Subject: RE: Planning Consultation on F/10/20/DOC

Engineers Comments Regarding Surface Water Drainage

APPLICATION NO: F/10/20/DOC

Description of Works: Approval of details reserved by condition imposed under ref F/5/19/PL relating to Condition No 5 - surface water drainage

Cellular Soakaway
Volume: 16.4m³
GL: 6.10mAOD
CL: 5.60mAOD
IL: 5.30mAOD

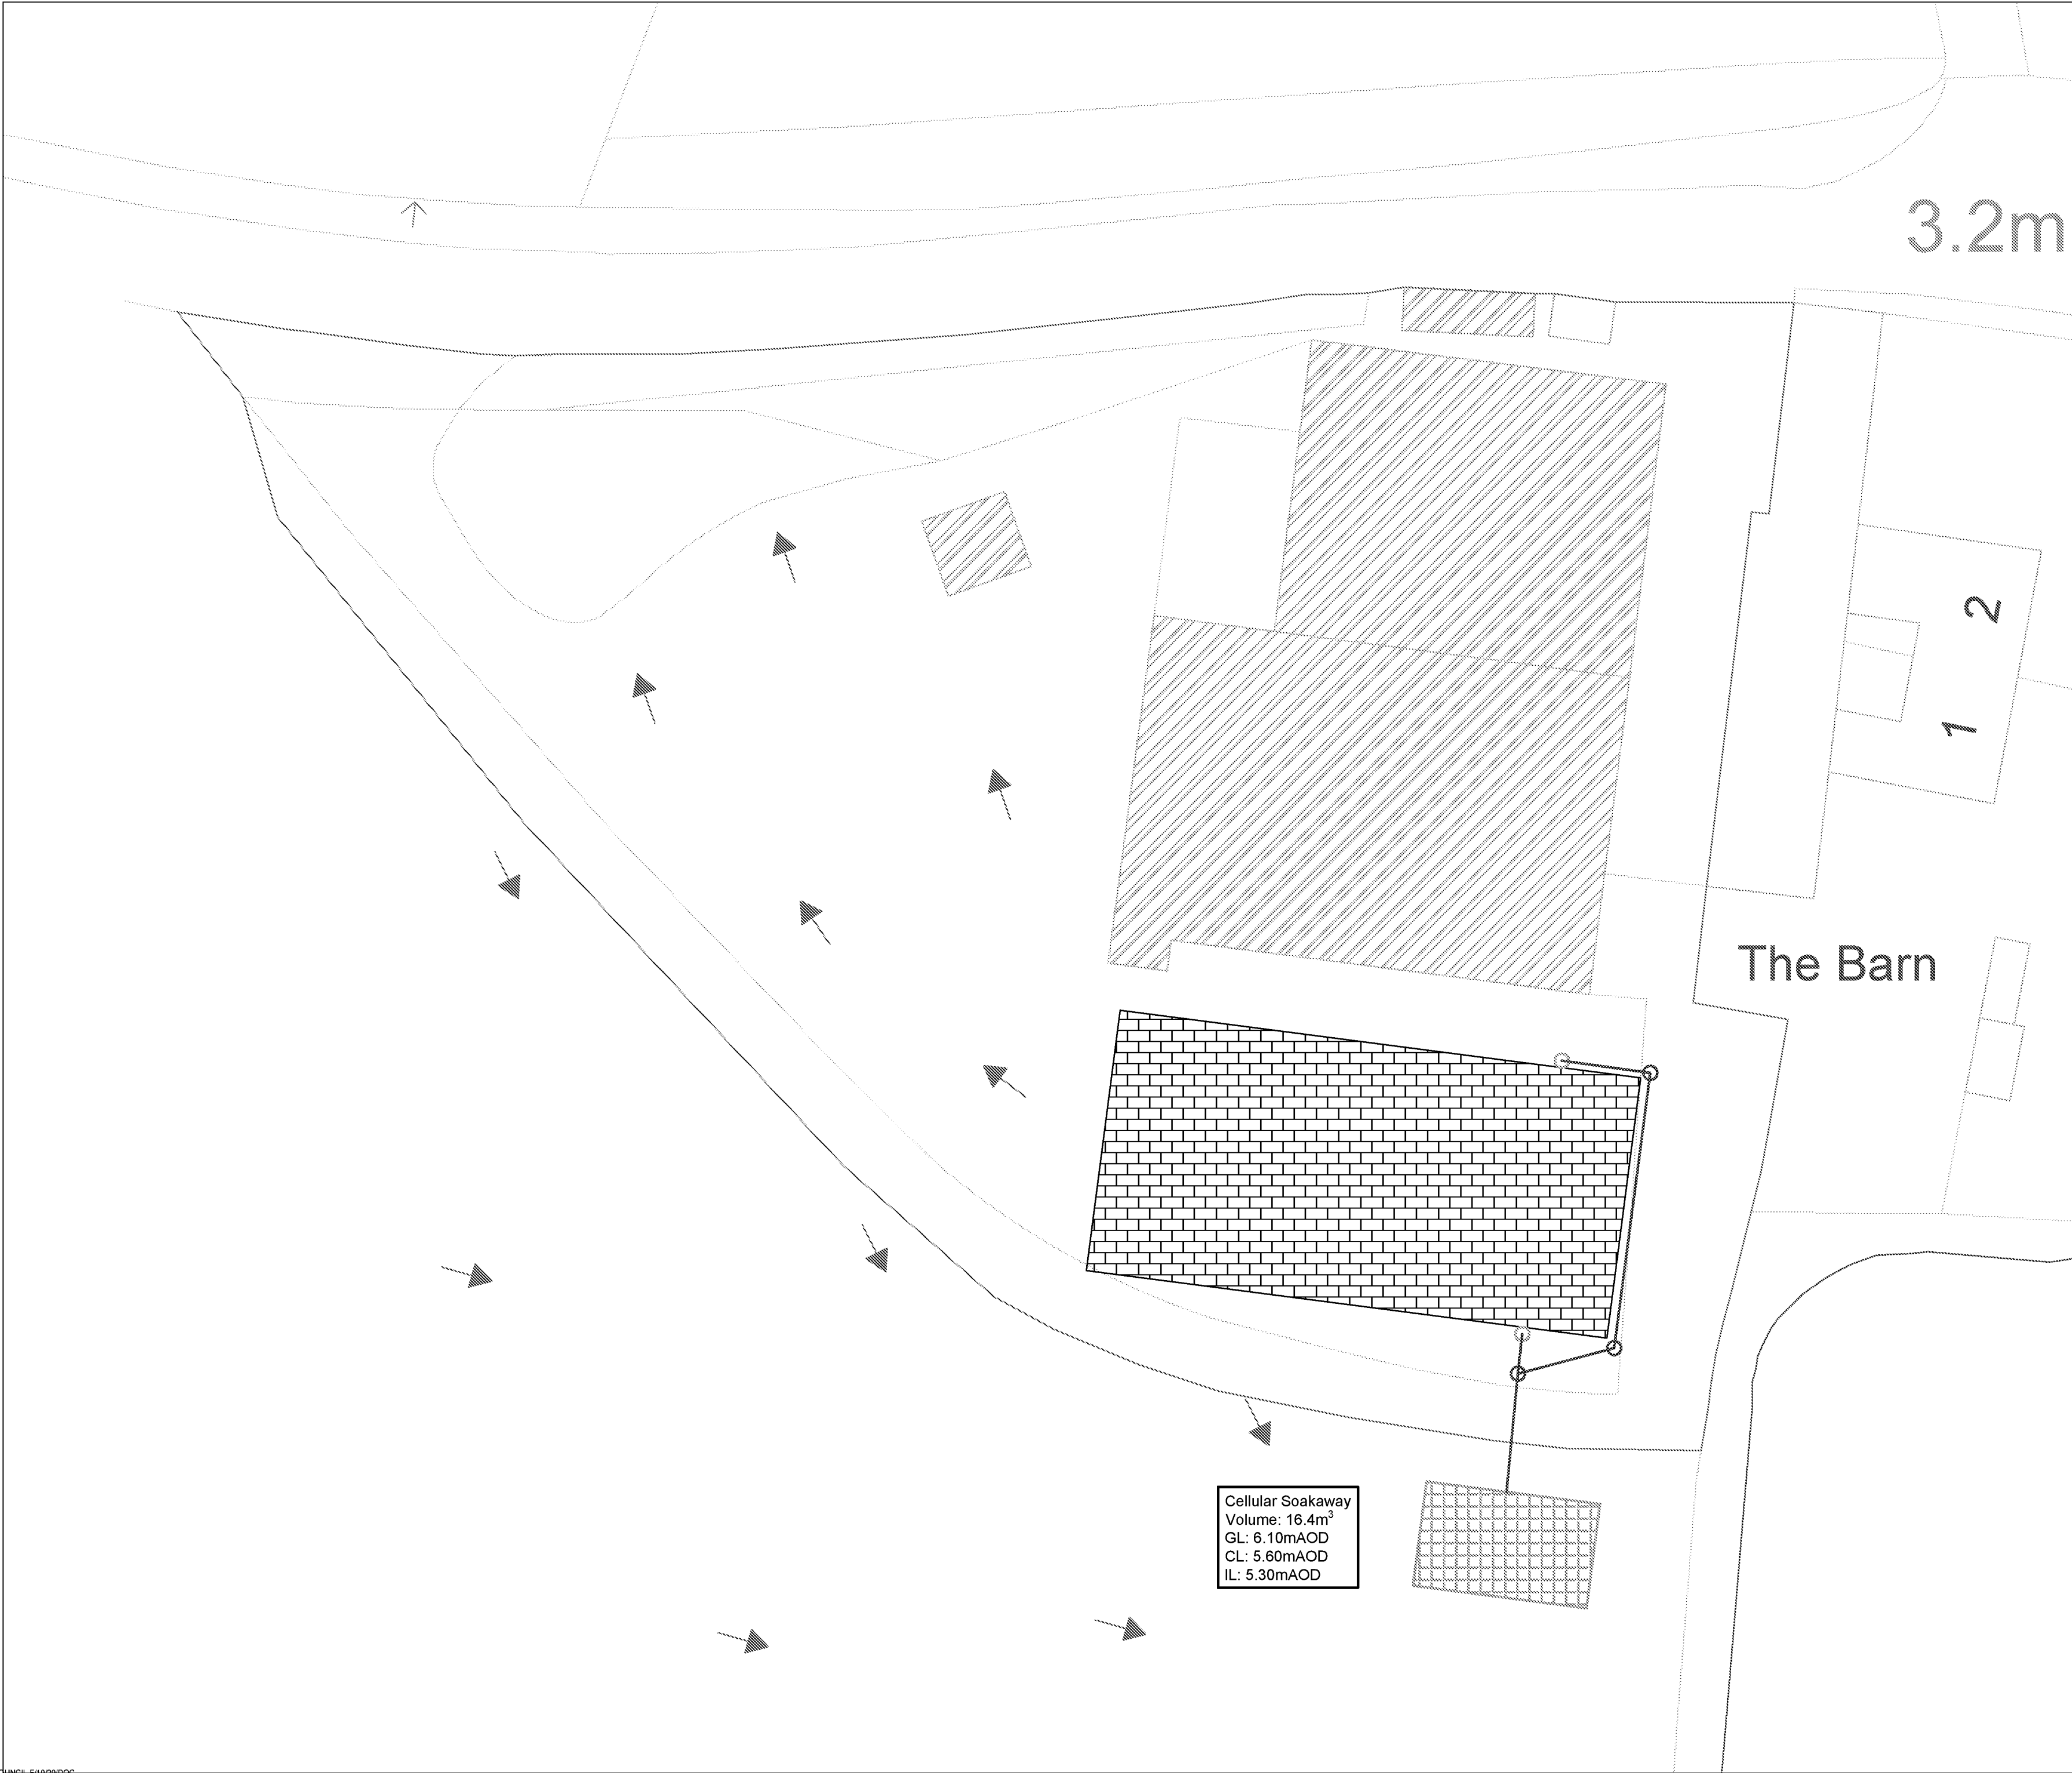
1: As the soakaway acts as a blanket with an effective depth of 0.3m it is appropriate to use the base for the calculations. However, the soakaway invert level is at 0.8mbgl, this depth does not correspond with the infiltration test depth of 1.77mbgl. If the infiltration test results are to be used then the soakaway base should be at the same depth as the testing (noted that this was at the top of the chalk stratum with clay above). There are two options:

- a) Make the soakaway deeper to correspond with the existing tests. The deeper soakaway may have to utilise the sides only for the calculations, please contact us to agree this in advance of a further submission.
- b) Carry out winter infiltration tests at the depth of the proposed soakaway and use these to inform the design, utilising the base in the calculations.

2: The Drainage layout requires more detail. We would expect to see the following as a minimum:

- a) Cover levels, types and invert levels for all inspection chambers and silt trap.
- b) Pipe diameters, pipe types and gradients/falls.
- c) The exact dimensions of the proposed soakaway, the crates to be used noted on this drawing.
